Cottam Solar Project

Schedule of Changes (Deadline 2)

PINS Reference: EN010133
Document Reference: EX1/C8.1.7_A
The Infrastructure Planning (Examination Procedure) Rules 2010
Rule 8(1)(k)

Any potential hedgerow removed associated the proposed Cable Route Corridor is shown on the additional Hedgerow Removal Plans [EN010133/EX1/C8.2.3].

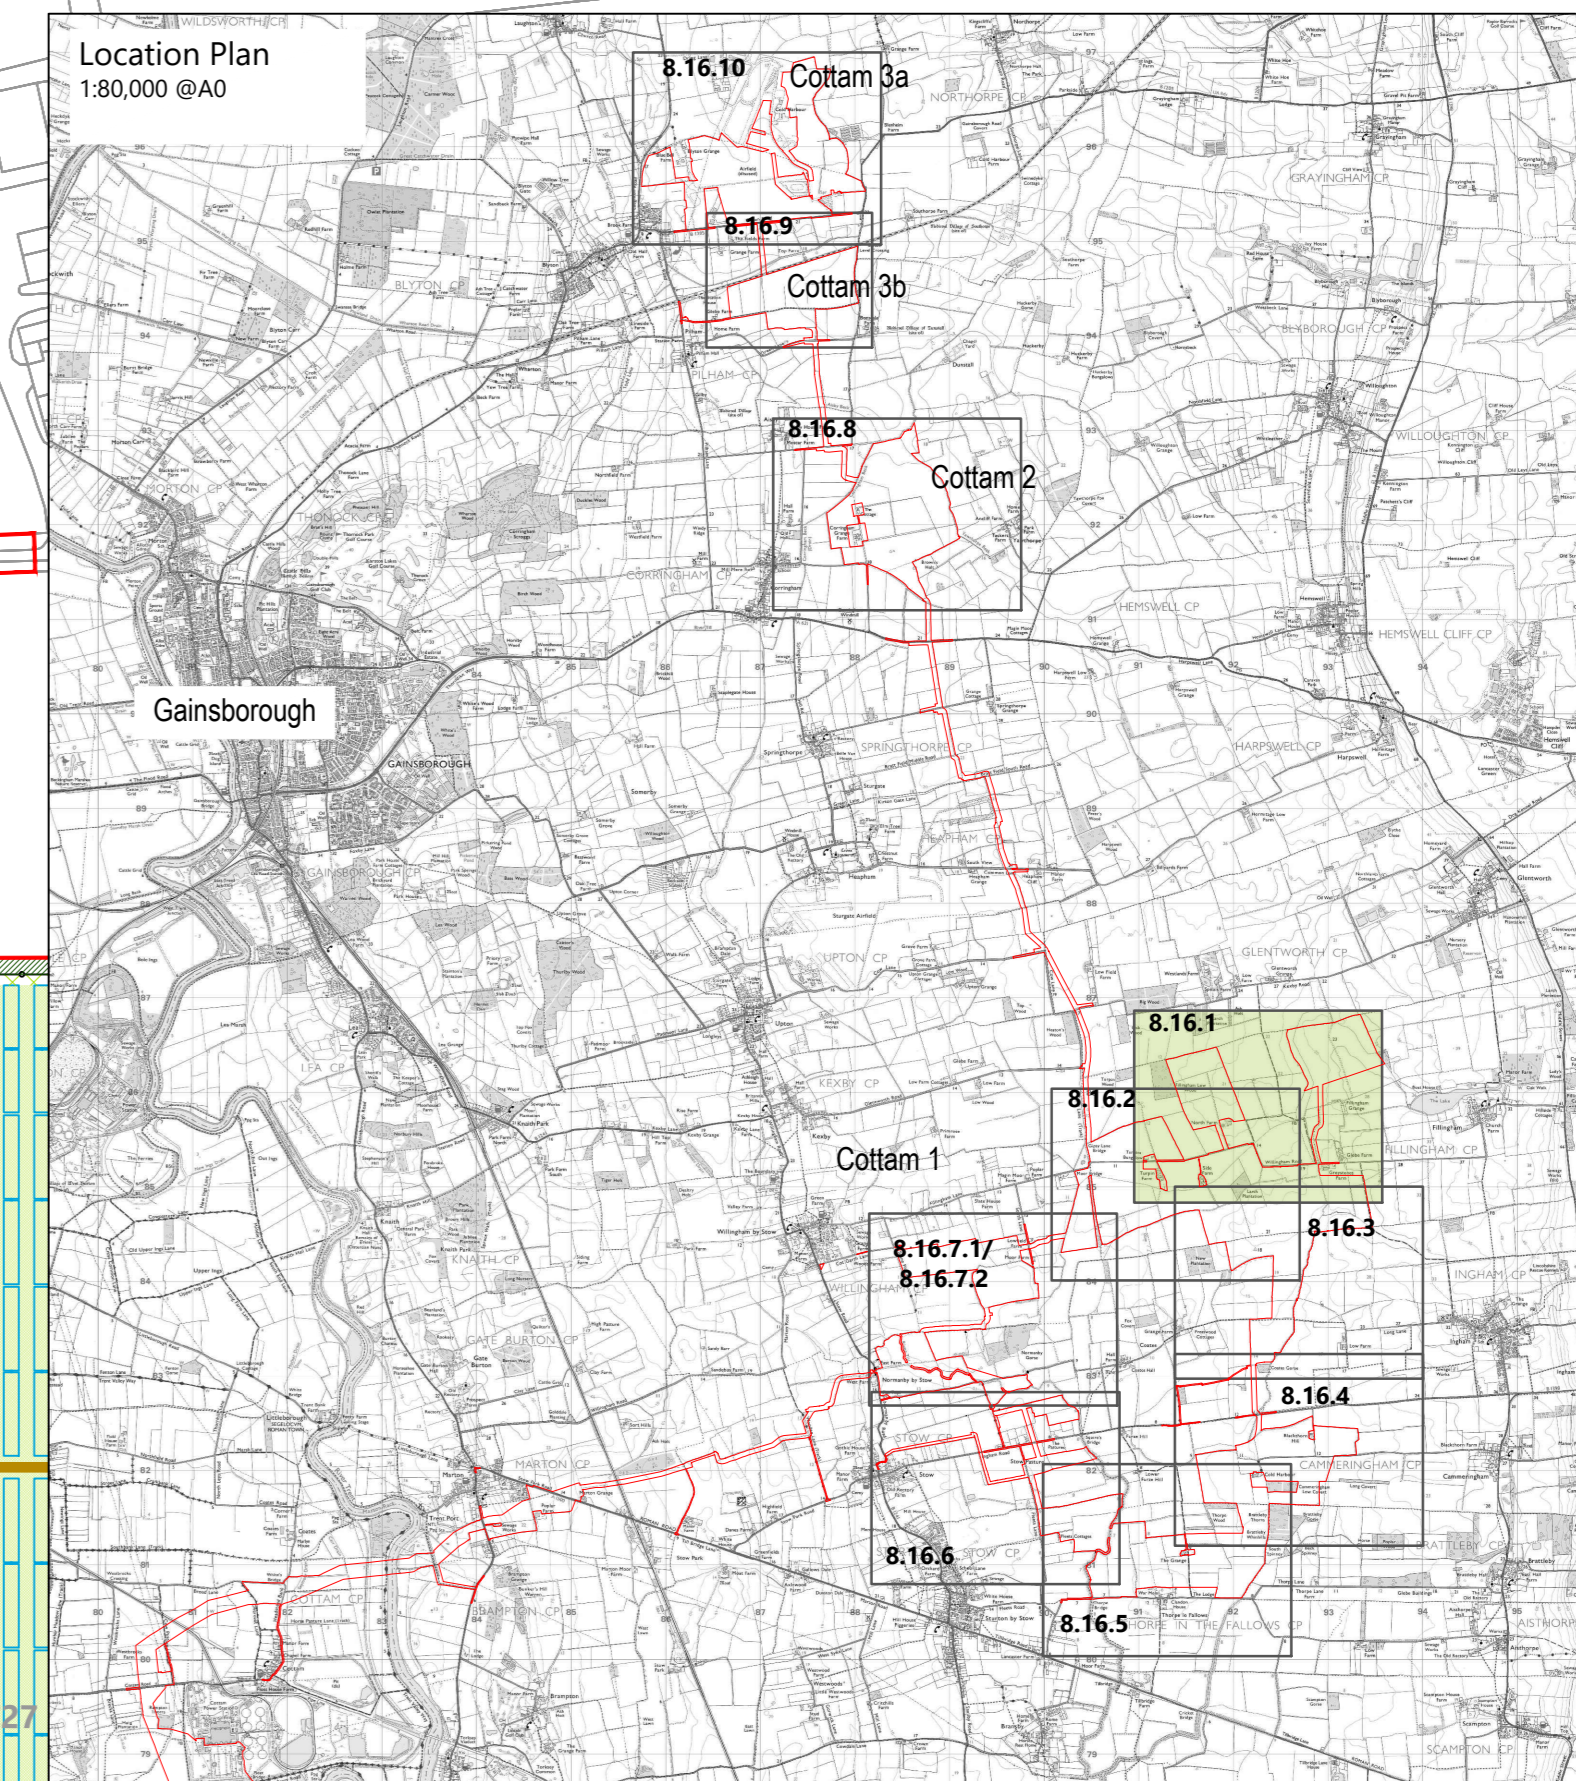
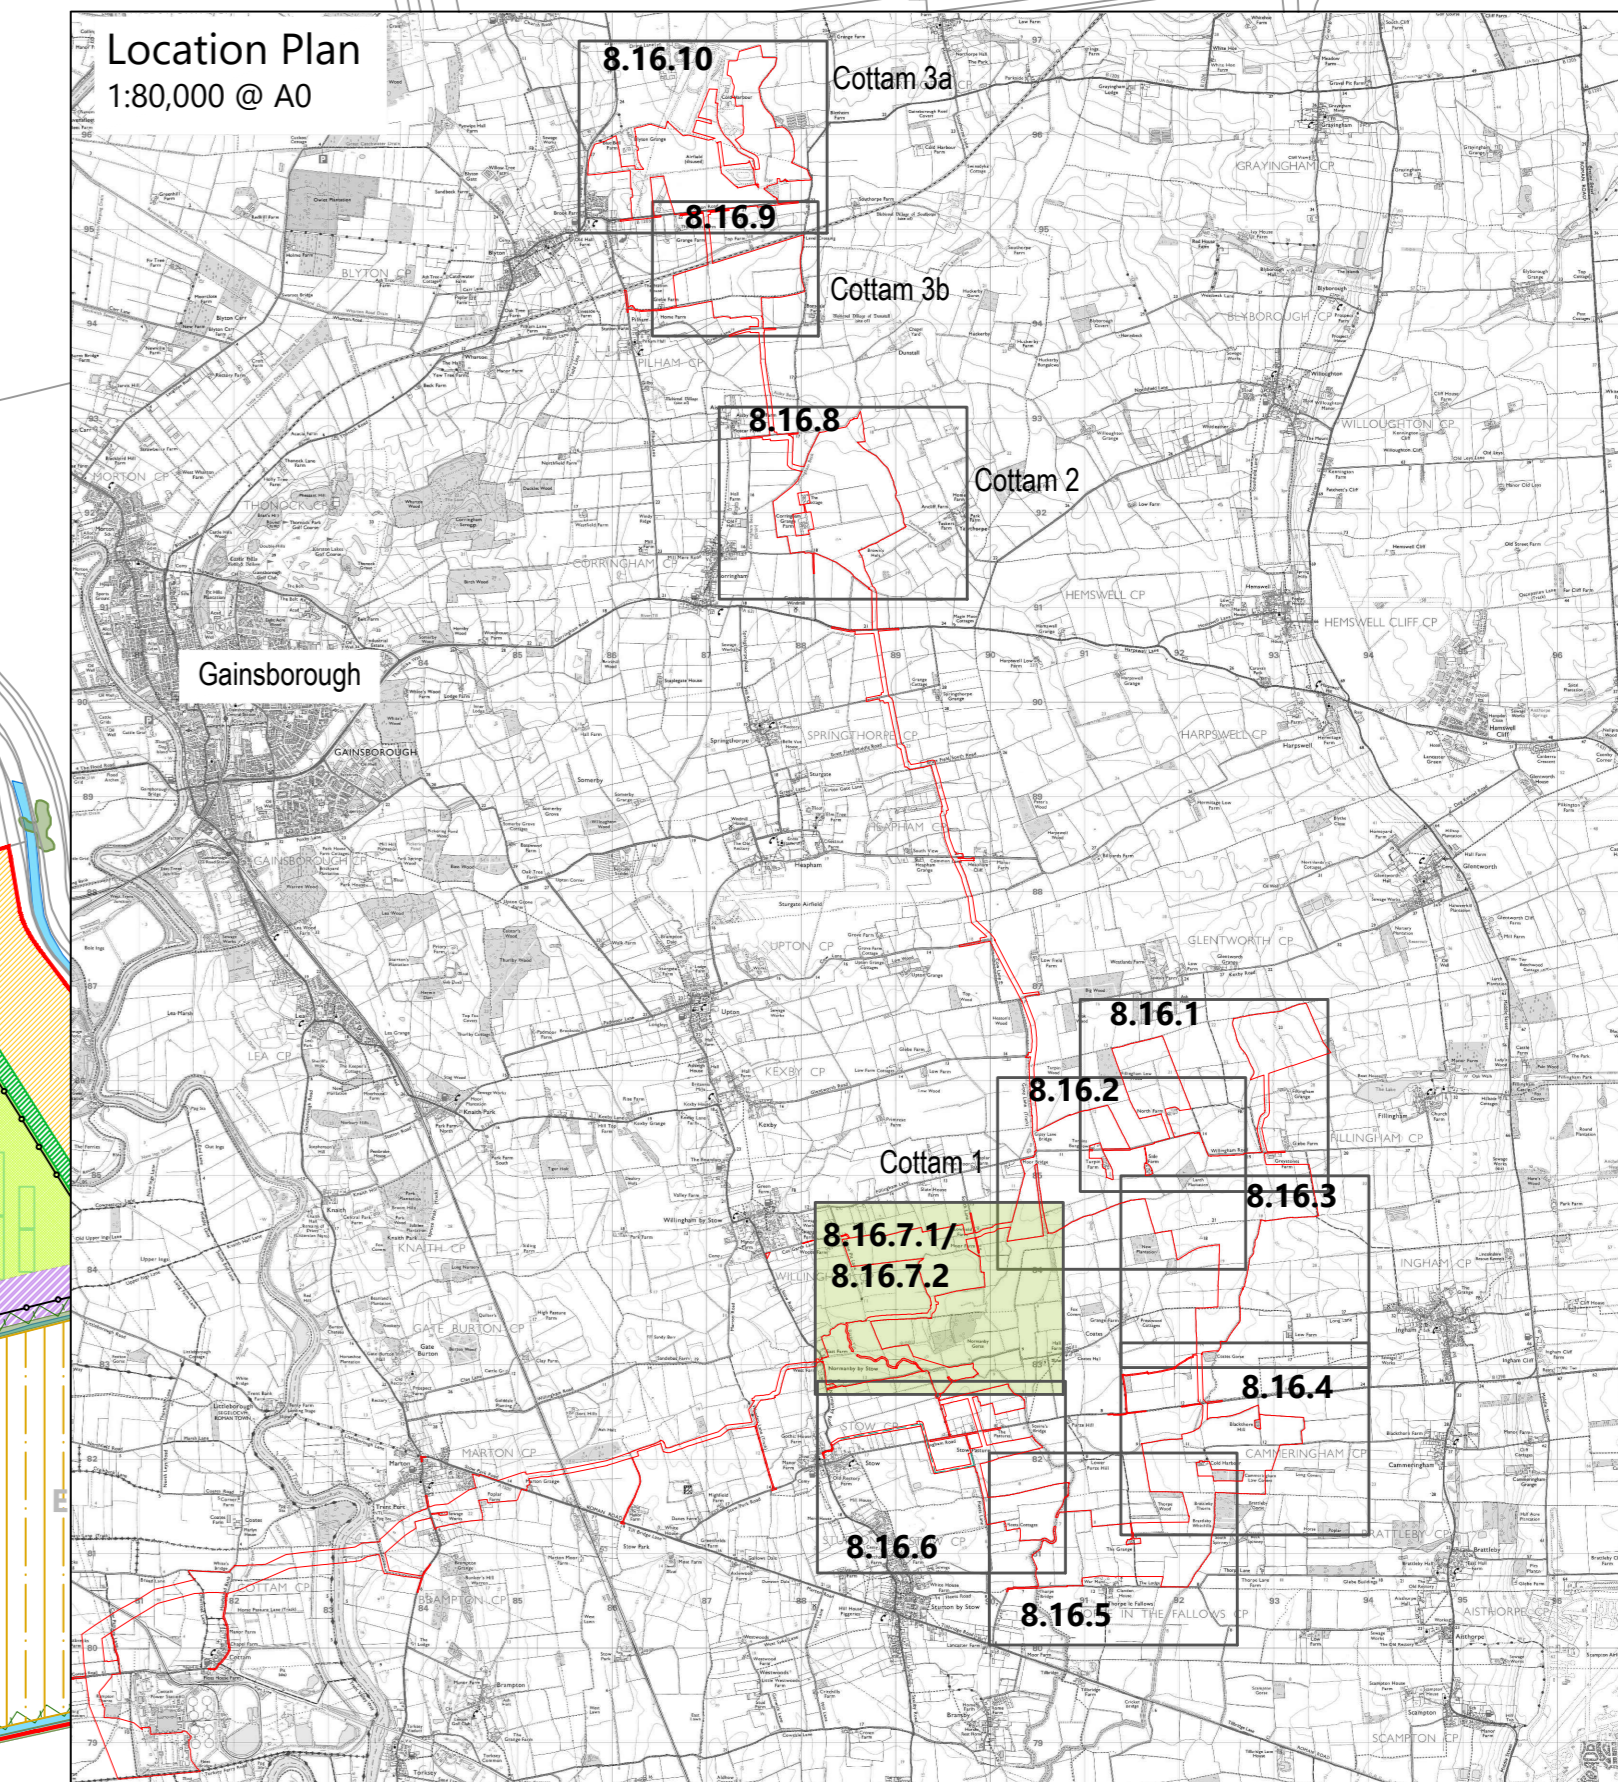
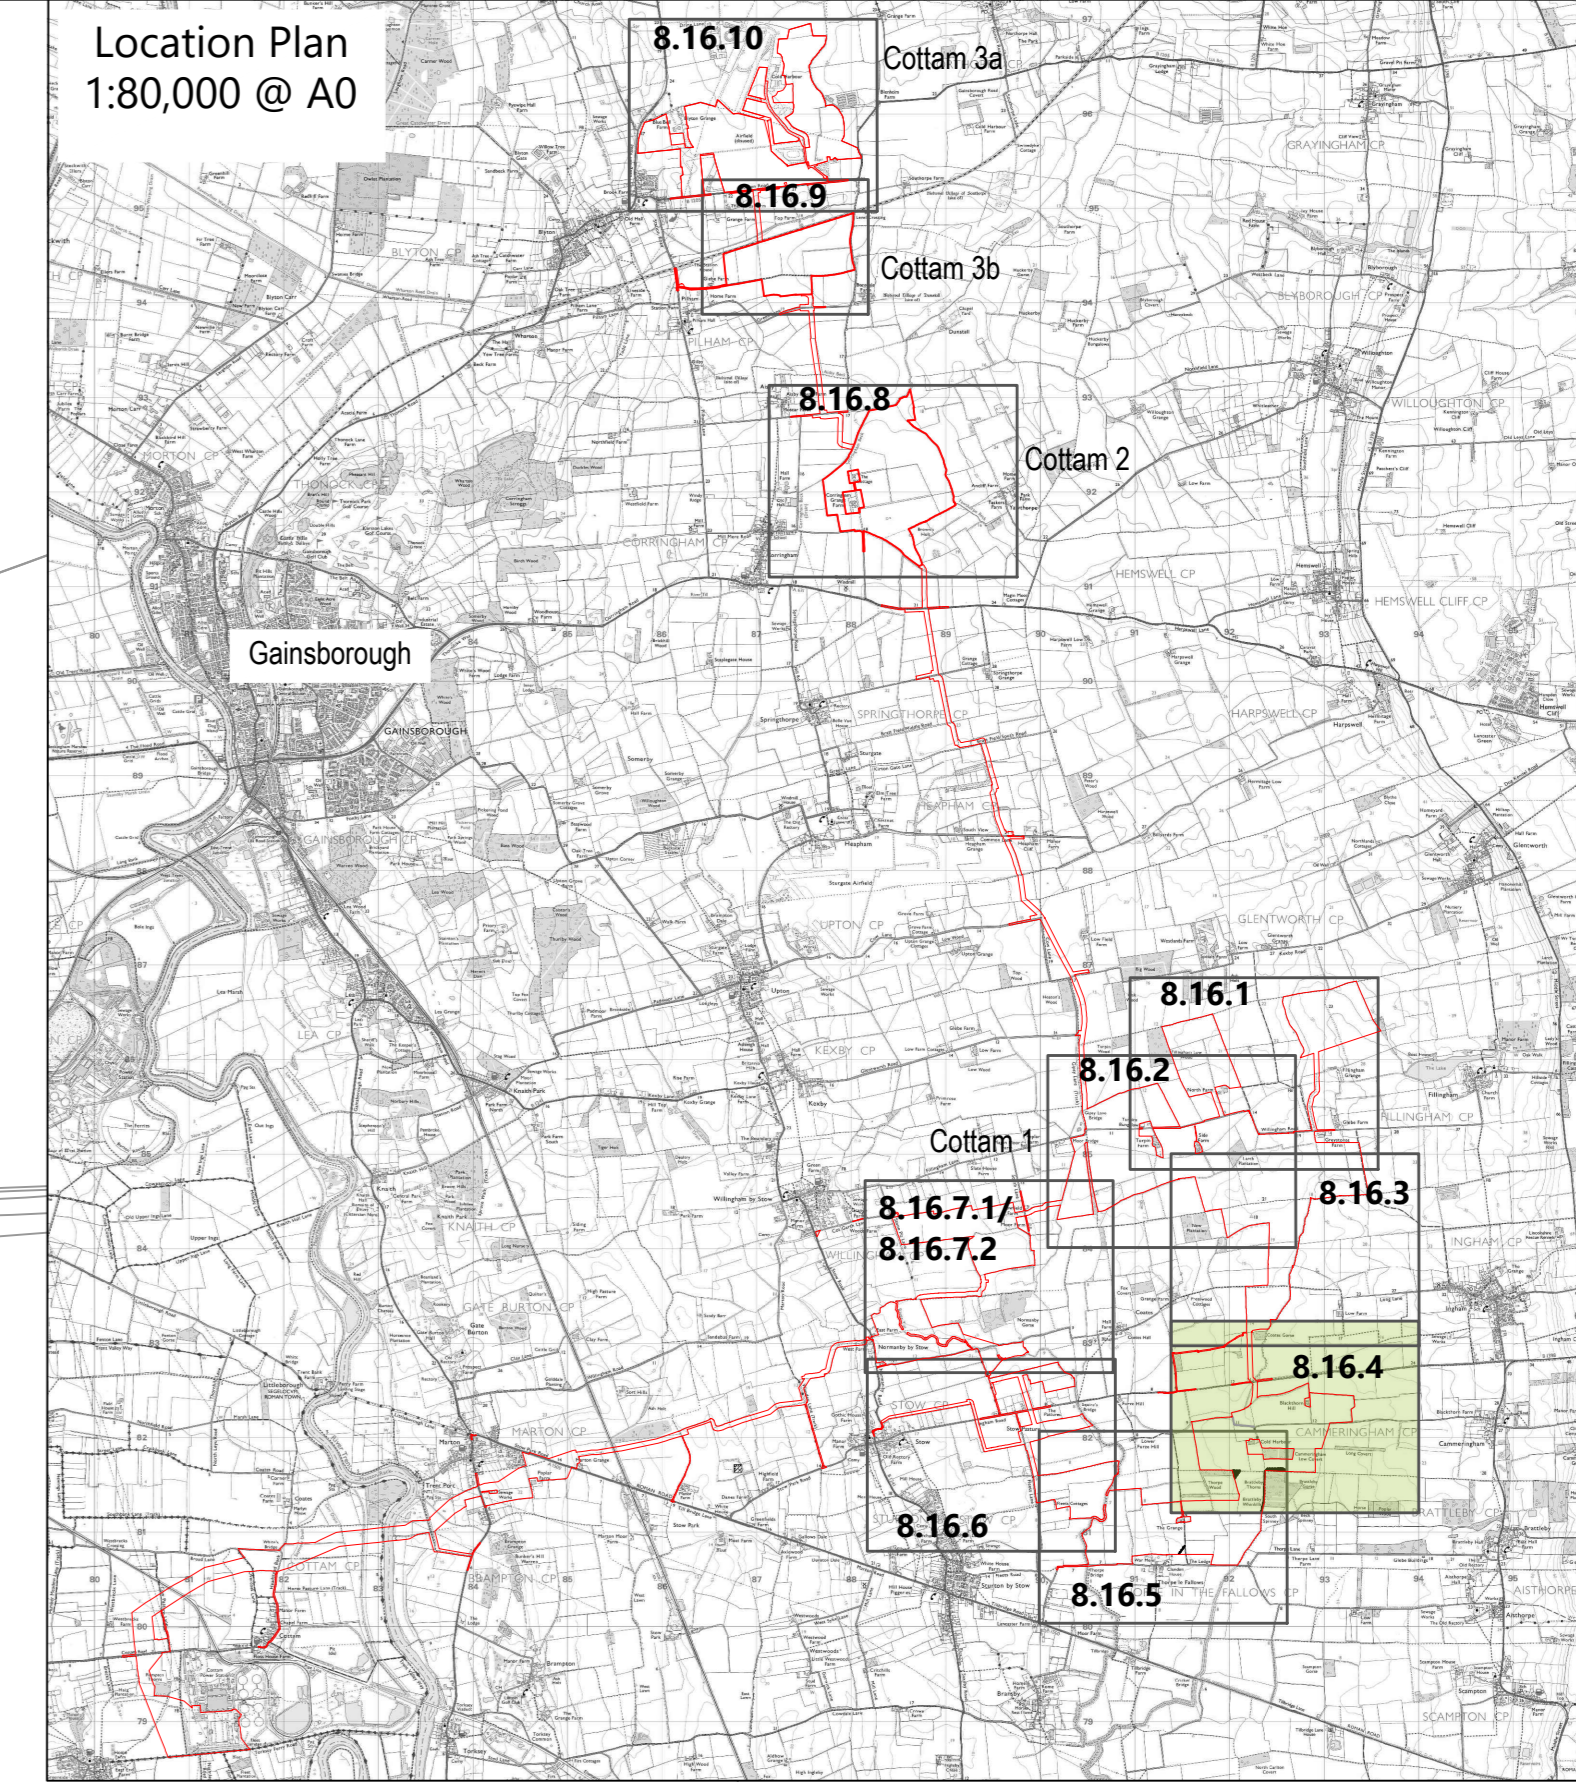
C6.4.8.16.1 to C6.4.8.16.10 Landscape and Ecology Mitigation and Enhancement Plans	[APP-305 to APP-315]	Revision A [EX1/ C6.4.8.16.1_A to EX1/ C6.4.8.16.10_A]	Deadline 1 17 October 2023	Correction of typos, to show additional hedgerows to be removed and to provide clarity of IDB Drain locations.	Minor editorial changes for clarity.
C6.5 ES Non-Technical Summary	[APP-336]	Revision A [EX1/C6.5_A]	Deadline 1 17 October 2023	Paragraphs 6.3.14 to 6.3.16, and 6.3.20 to 6.3.21, updated clarifying as to which part of the Site, and which assessment period the effects relate to.	To provide clarity and consistency and minor editorial changes.
